NORTH FALLS

Offshore Wind Farm

Applicant's Response to Deadline 6 submissions

Document Reference: 9.102
Volume: 9
Date: July 2025
Revision: 0

Do not scale from this drawing								
All dimensions are to be verified on site								
© Drawing & design copyright LUC								
				Drawing Nr		12155-LUC-00-VS-L-0006		
						Rev P03

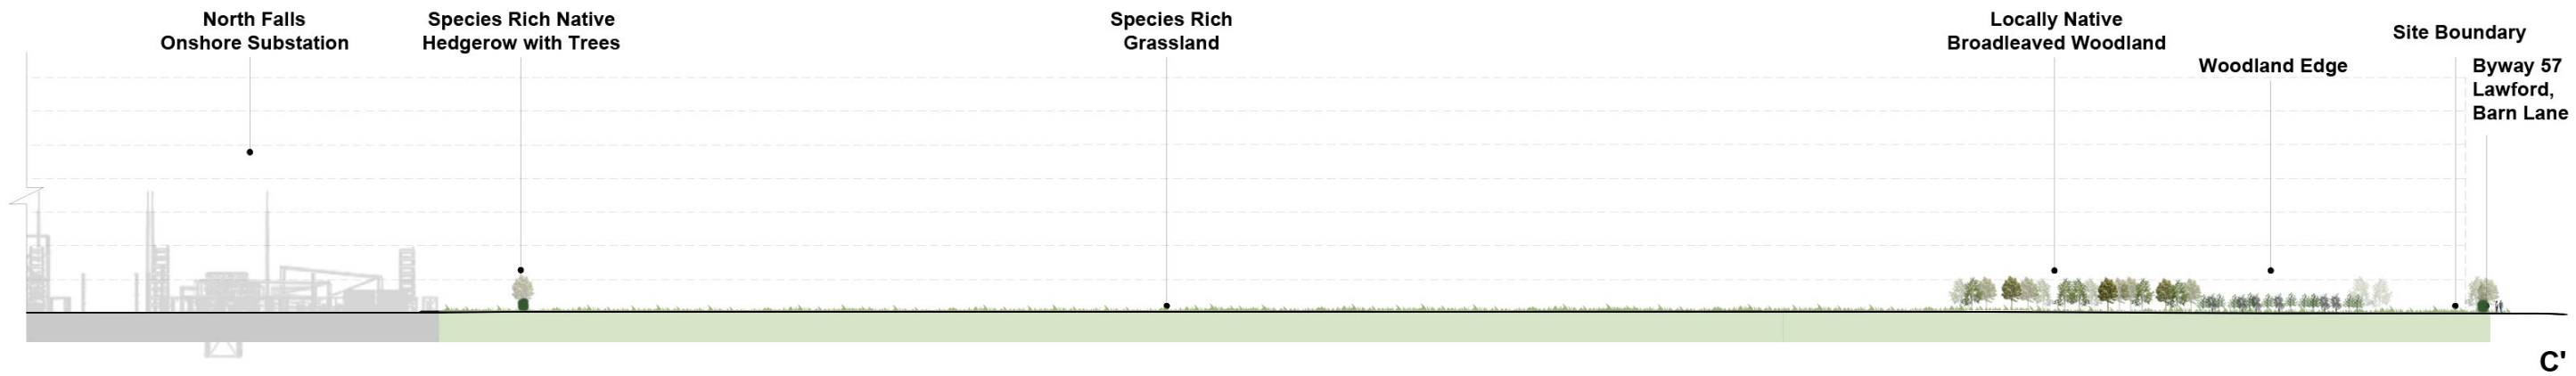
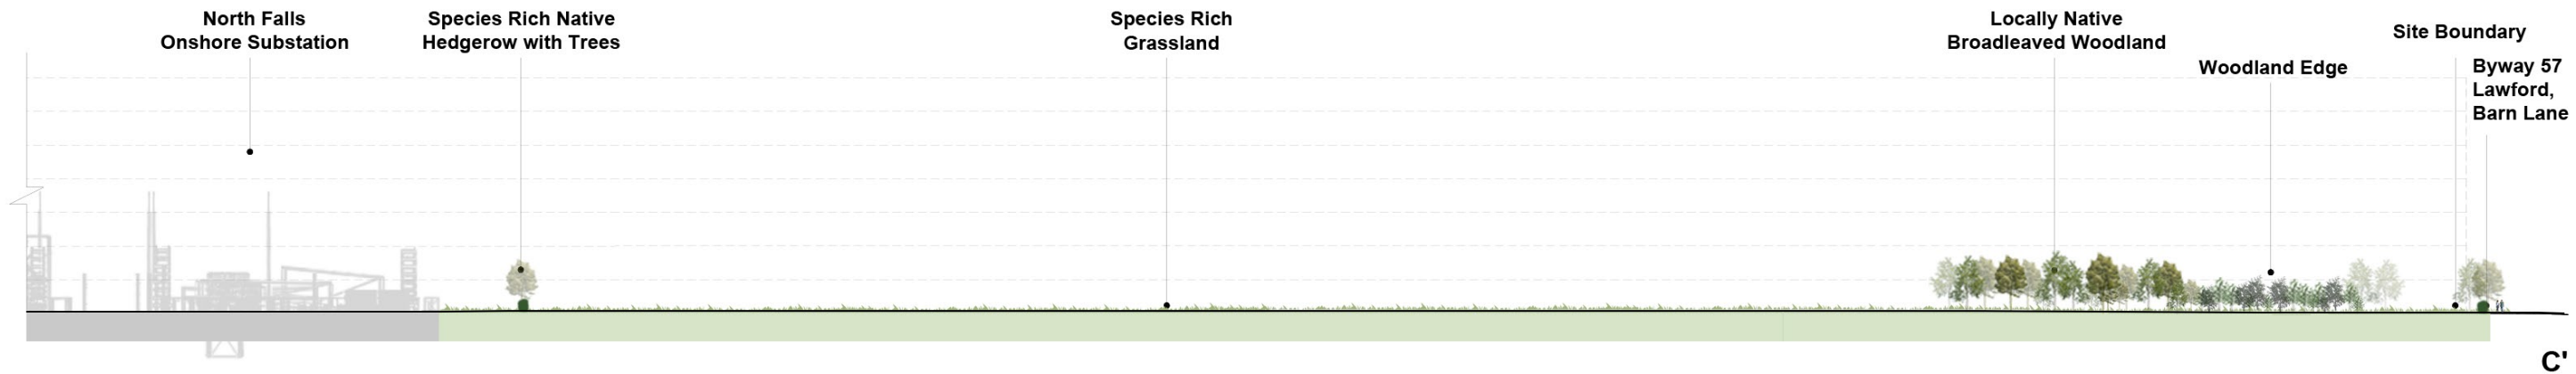
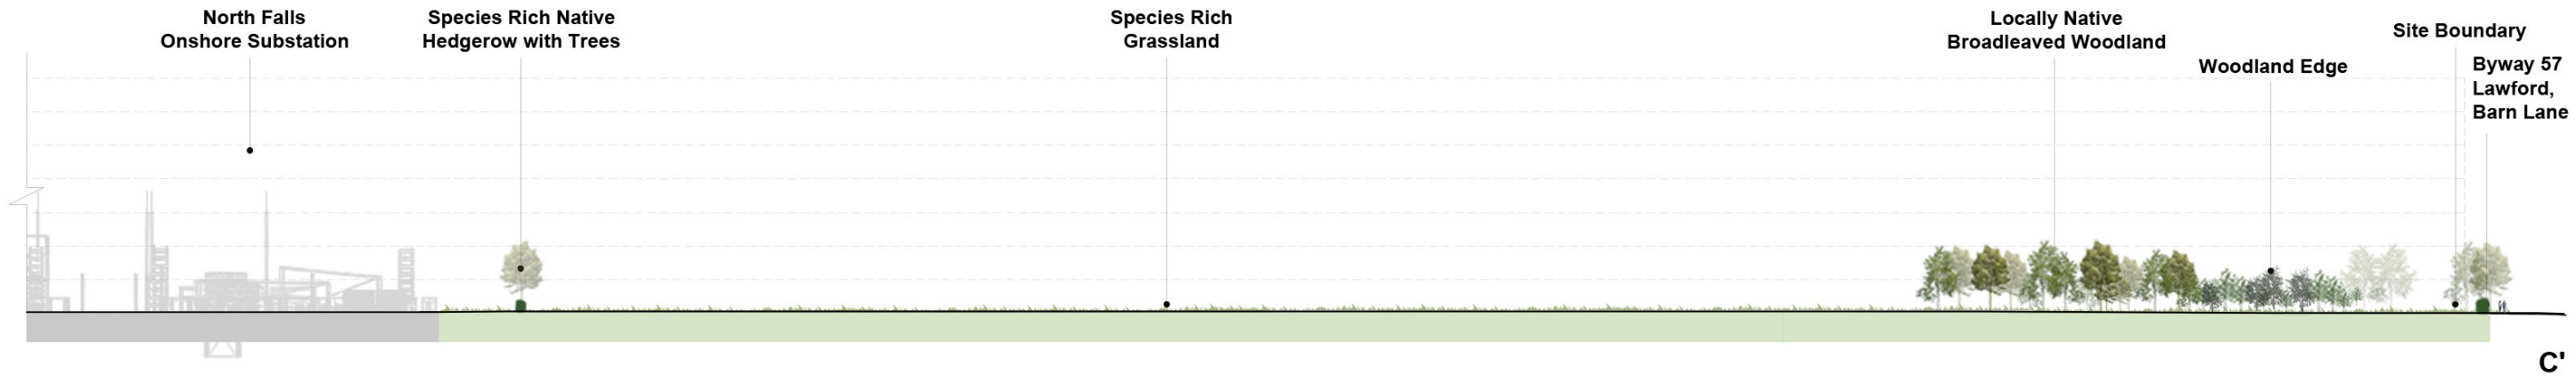
REP6-081_c	Public Rights of Way	As there are currently large open patches along the southern side of the Barn Lane byway, the new substation would be highly visible to the byway users. It would be	The Landscape Mitigation Plan provided in Appendix A of the Outline Landscape and Ecological Management Strategy (Rev 5) [REP6-035] and Sheet 6 of the Indicative planting cross-sections

REF	THEME	ESSEX COUNTY COUNCIL AND TENDRING DISTRICT COUNCIL COMMENT	APPLICANT'S RESPONSE
		beneficial to provide landscape screening, set at a suitable distance from the narrow byway.	at the onshore substation [REP5-035] highlights that there will be proposed tree and hedgerow planting between Barn Lane and the proposed North Falls onshore substation to the south. The proposals include the infill of any open stretches of the existing hedgerow. Shelter belt planting is also proposed to the south of the hedgerow to screen the onshore substation from byway users.
REP6-081_d	Landscape - REP5-005 - Document 2.3 Design Vision (Rev 1)	We welcome the proposal of a Joint Design Guide between North Falls and Five Estuaries projects identified in the Design Vision. Our concerns remain as to the extent and character of the proposed landscape strategy. In this we support the concerns identified by the Design Council that a wider vision for landscape is required.	The Applicant will continue to work with the Five Estuaries project team to develop a Joint Design Guide and associated landscape strategy. Consideration of how the Project's landscape mitigation and ecological enhancements integrate with the wider landscape is a key consideration during the development of the Joint Design Guide, and the final Written Landscaping Scheme secured under Requirement 7 of the Draft DCO [REP6-005] . Please also refer to the Applicant's response to Q8.0.4(iv) in the Applicant's Response to ExA's Third Written Questions (ExQ3) [9.113 (Rev 0)] and the Applicant's response to REP6-081_e below.
